**KITITIAS COUNTY**  
**DEPARTMENT OF PUBLIC WORKS**

June 19, 2018

RE: Phase 3 Division 14  
Engineering Plan Submittal

**NEW SUNCADIA LLC
 PHASE 3 DIVISION 14
 COMPOSITE UTILITY PLAN**
 WASHINGTON
 KITTITAS COUNTY

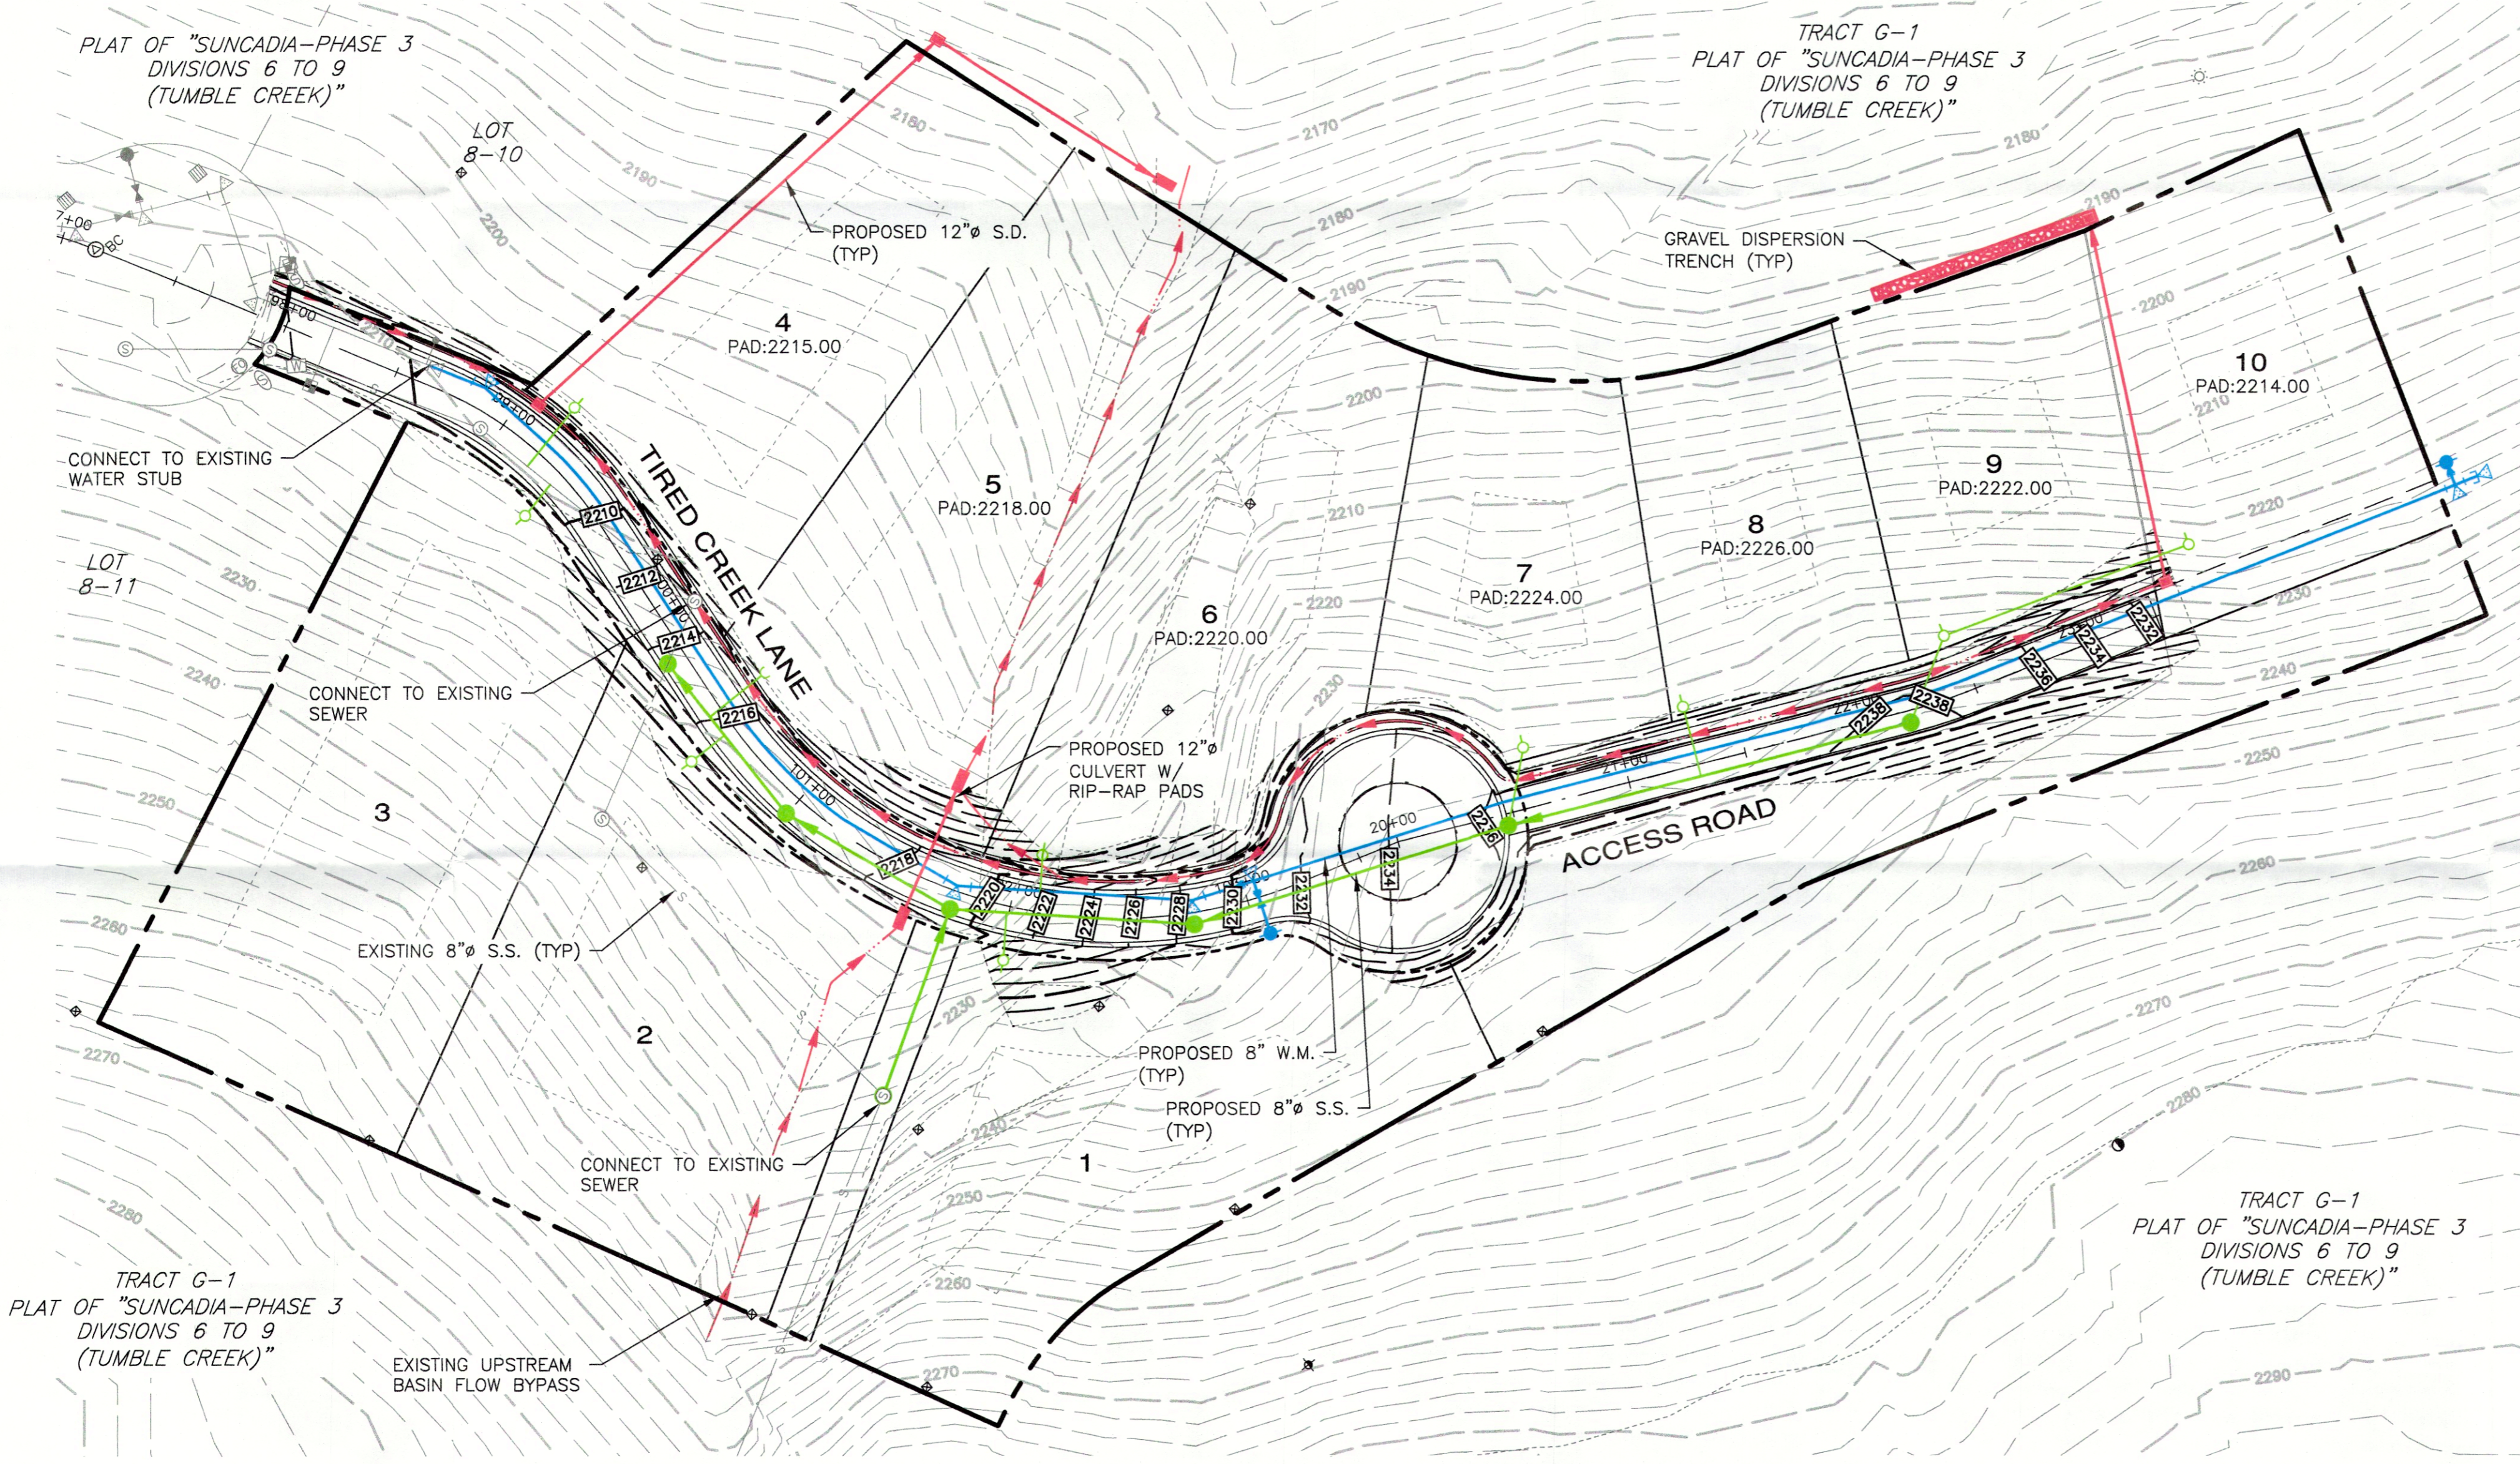
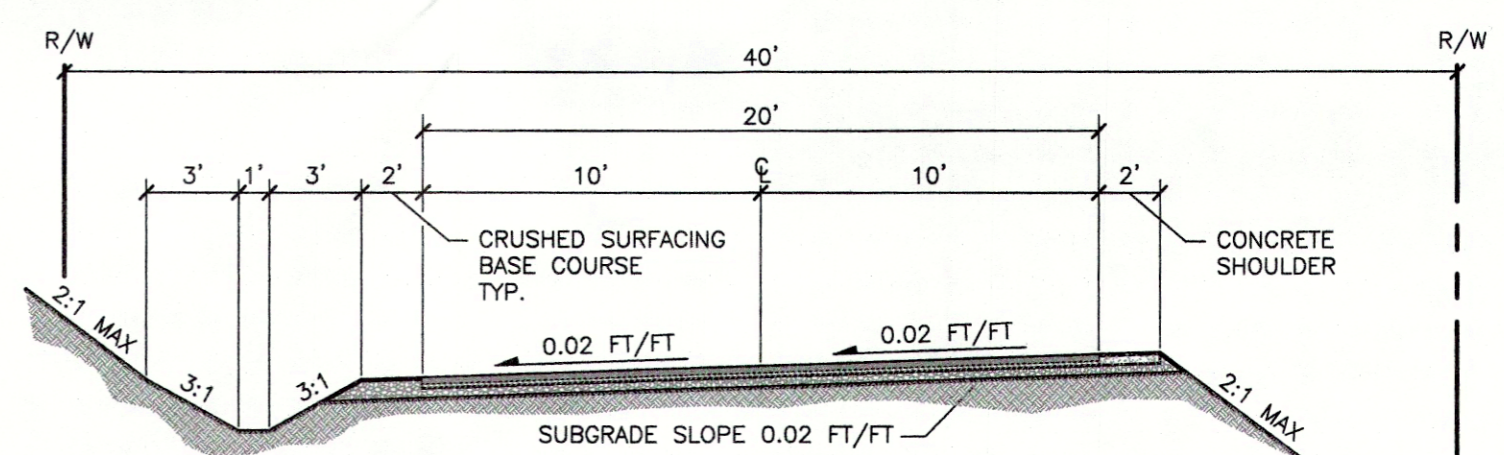
1. Please provide a road design profile for Tired Creek Lane and the access roadway east of the cul de sac.
2. Please provide roadway geometric data (horizontal alignment).
3. Please provide supporting stormwater design calculations. Please discuss the capacity of the facility in the golf course and the anticipated capacity utilized by this proposal.
4. It appears that the sanitary sewer (8 inch) connects westerly to Phase 3 Divisions 6 to 9. Please verify that all sewage flows are gravity flows from Phase 3 Division 14.
